The Member-Secretary,
Madras Metropolitan
Development Authority,
8, Gandhi-Irwin Road,
Madras:600 008.

Letter No. B2/13616/94.

Sub: MMDA- APV- Revised Proposal -

of Constat related to G+3F Comul Cum Reside
bldg with 15 dwelling units at 7 S. NO. 178/1,
BK NO. 9, Door no. 27, Andavar kail St.
Vadapalani.
Remittance of DC + SF.
Requested regarding.

SITE PLAN

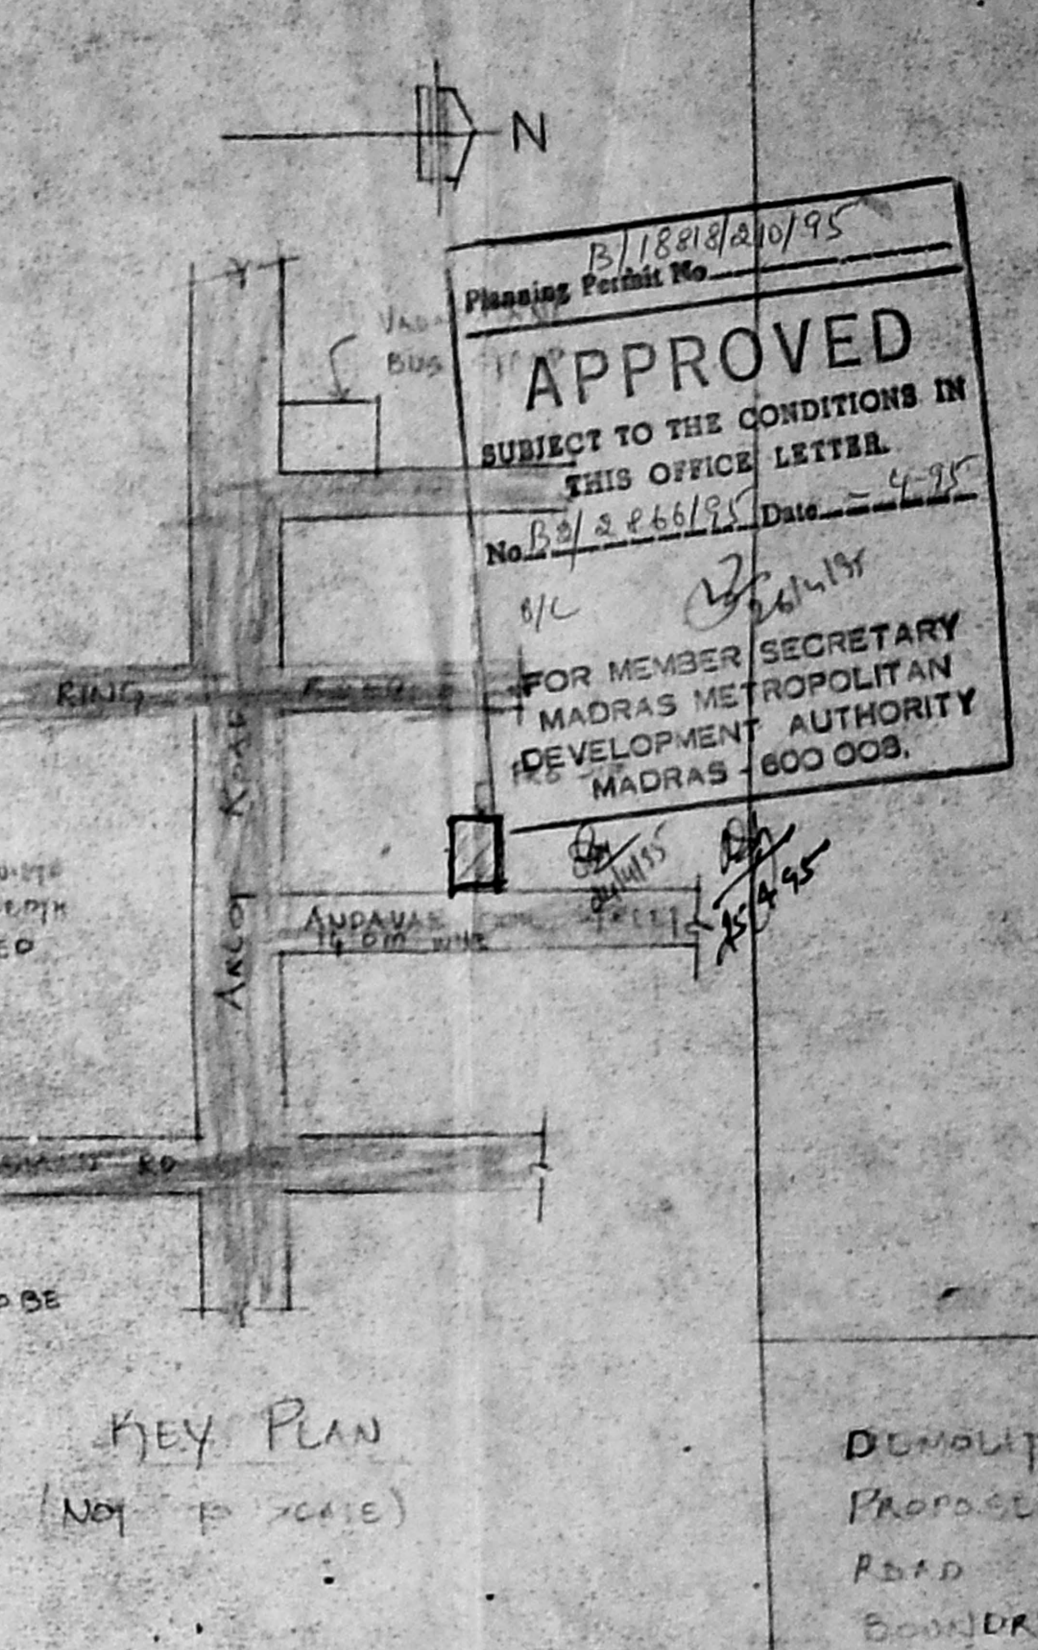
(d) © (a) You are requested to furnish RP by providing Entry to site, and showing the projections in site plan) ~~Stop existing~~ (Front set back)
~~(b) North East corner to be demarcated.~~
(b) You are also requested to demark the shop exist at North East corner and inform this office about it
